**UNITED WAMBO OPEN CUT COAL MINE PROJECT AND HUNTER VALLEY
OPERATIONS MODIFICATION 5 – CUMULATIVE AIR QUALITY IMPACT
ASSESSMENT PEER REVIEW**

Date 21/07/2017

Ramboll Environ Australia Pty Ltd (Ramboll Environ) was engaged by Department of Planning and Environment (DPE) to undertake an independent peer review of the Air Quality Impact Assessment (AQIA) reports undertaken by Jacobs Group (Australia) Pty Limited (Jacobs) for the United Wambo Open Cut Coal Mine Project (SSD 7142, hereafter UWOC) and by Todoroski Air Sciences (TAS) for the Hunter Valley Operations South Modification 5 (PA 06_0261 MOD 5, hereafter the HVOS) at the existing Hunter Valley Operations South Coal Mine.

Figure 2 Location of meteorological stations for CALMET modelling

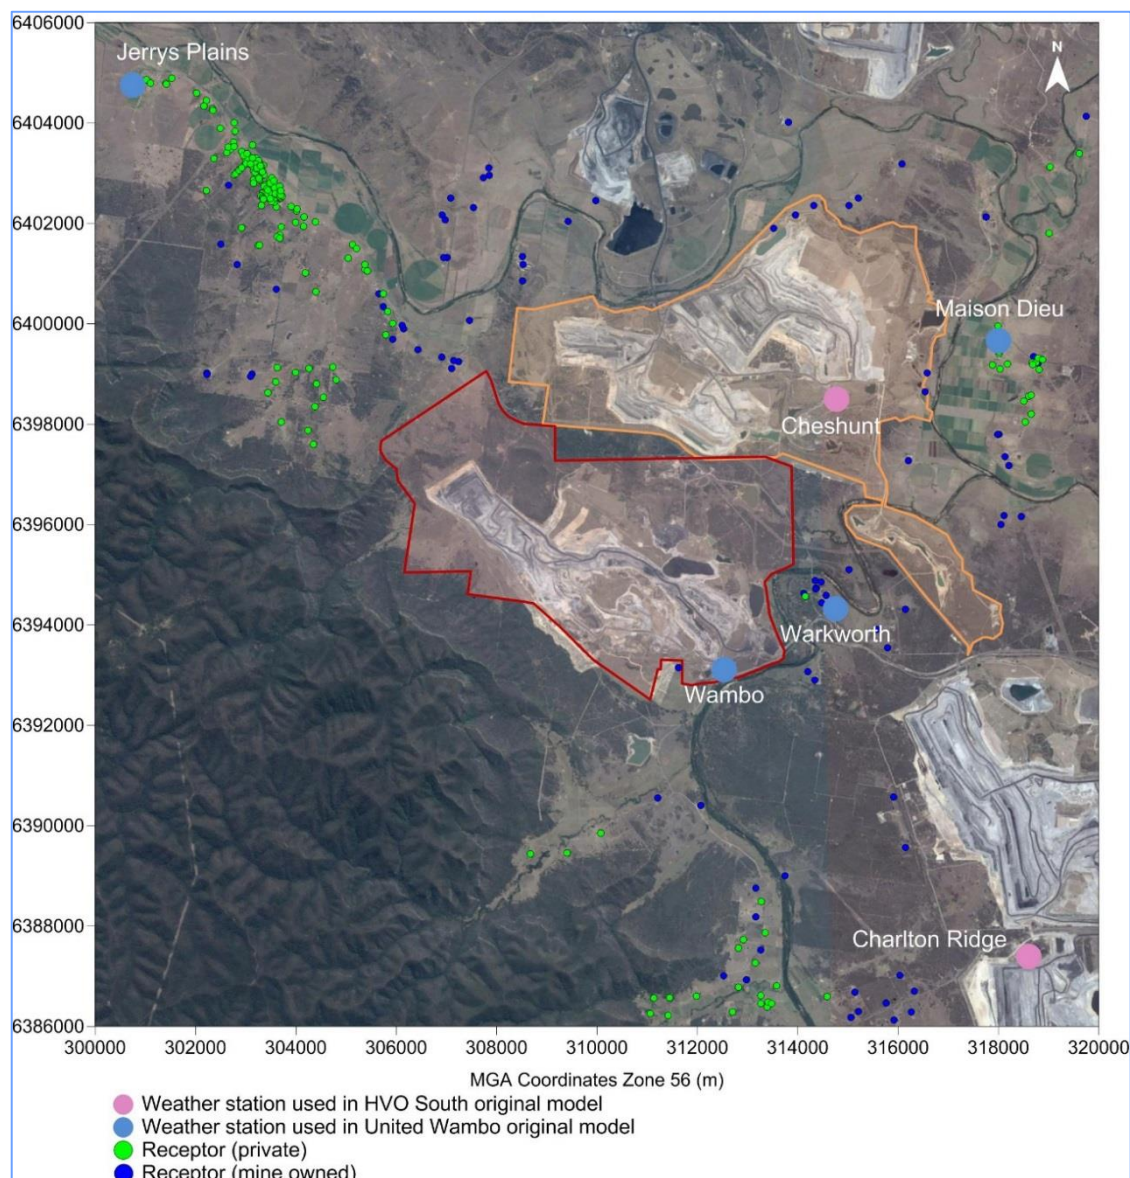
While both assessments used the accepted TAPM/CALMET meteorological modelling approach and modelled for the 2014 calendar year, different local meteorological datasets were used as input. The UWOC model integrated observations from the Wambo Coal weather station along with meteorological observations from the NSW OEH Warkworth, Jerrys Plains and Maison Dieu stations. The HVOS model used observations from the Coal and Allied stations at HVO North, Cheshunt and Charlton Ridge.

While all stations used in the two assessments are considered appropriate resources for the purpose of meteorological inputs, the use of a different set of 2014 input datasets could lead to subtle differences in predicted local dispersion conditions that could lead to potentially significant differences in predicted concentrations.

For example, the closest meteorological stations to Warkworth village from each model are NSW OEH Warkworth station in the UWOC assessment and the HVOS Cheshunt station in the HVOS assessment, located approximately 3km to the north of Warkworth. The 2014 annual wind roses from the NSW OEH Warkworth station (wind rose sourced from Umwelt 2017) and the HVOS Cheshunt station (wind rose sourced from TAS 2017a) are presented in **Figure 5**. It can be seen that the two datasets vary in both wind speeds (the Cheshunt dataset contains higher winds) and direction (winds from the west-northwest to north-northwest occur 22% of time in Warkworth dataset and 38% of the time in the Cheshunt dataset).

This basic focus on just two of the local meteorological datasets illustrates that consistency of input meteorological datasets is important to achieve consistent dispersion model results in a cumulative impact assessment. Differences in input meteorological datasets may therefore have contributed to the identified differences in the predicted cumulative concentrations between the UWOC and HVOS assessments.

Meteorological modelling should therefore be completed for the justified base case year (2014 from the two assessments) with the integration of the following local observation stations, at a minimum:

- Wambo (Wambo Coal);
- Cheshunt (HVO South);
- HVO (HVO North);
- Charlton Ridge (MTW);
- Jerrys Plains (NSW OEH);
- Warkworth (NSW OEH);
- Maison Dieu (NSW OEH);
- Camberwell (NSW OEH);
- Bulga (NSW OEH).

Recommendation: Cumulative modelling study should integrate all available meteorological monitoring sites that meet input dataset requirements.

Figure 5 Predicted cumulative annual average PM_{10} concentrations due to the proposed projects, other mines and background levels

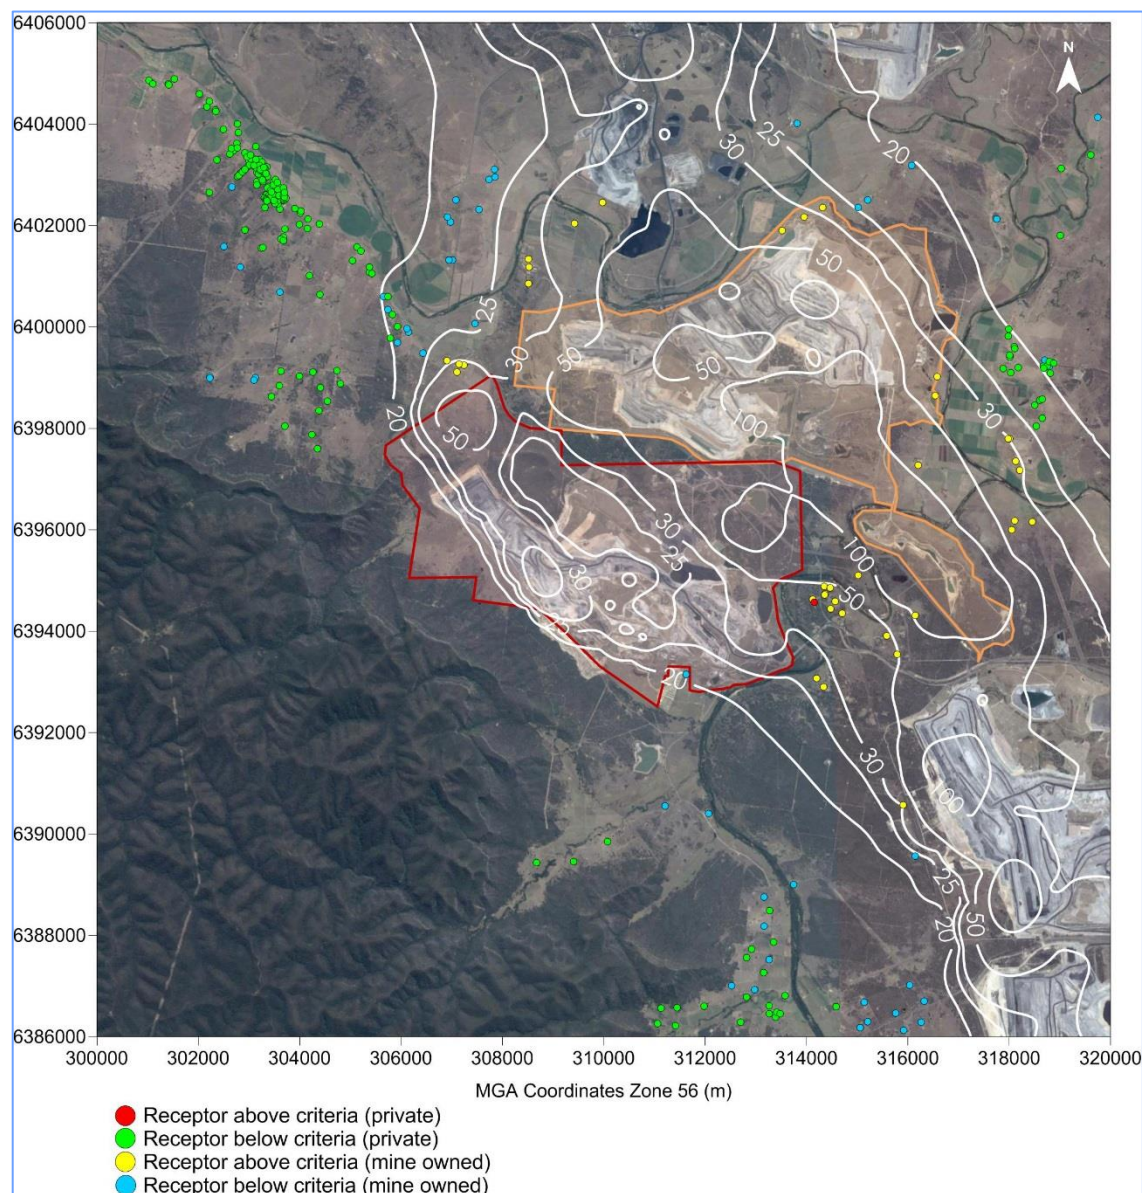
It can be seen from the results presented in **Figure 1**, **Figure 2** and **Figure 3** that notable differences in predicted cumulative annual average PM₁₀ concentrations exist between the two assessments. The largest differences between the two assessment predictions occur to the east and west of the HVOS boundary (out to approximately 3km), where the HVOS assessment predicts higher concentrations, however there are also notable differences to the east (Warkworth village) of UWOC.

It is considered that the primary reason for difference in predicted cumulative results between the two assessments is the adopted particulate matter inventories for neighbouring mines. In particular, the inventory for the UWOC is notably different between the two assessments. TAS (2017a) notes that due to the timing of the HVOS assessment, an approximation of the UWOC emissions inventory had to be made based on preliminary information. This was ultimately shown to be 70% to 80% higher than the emissions presented in the UWOC assessment.

To achieve consistency across the two assessments, cumulative analysis of impacts should be conducted using the same emissions databases for the two projects (UWOC and HVOS) and include the same surrounding mines. At a minimum, it is considered that mining emissions for each year selected from the following operations (as applicable to that year) should be quantified:

Recommendation: Emissions from neighbouring mine sites should be quantified in a consistent manner for matching current scenario year and future years. Future years should be selected collaboratively to ensure potential worst-case impact years are accounted for.
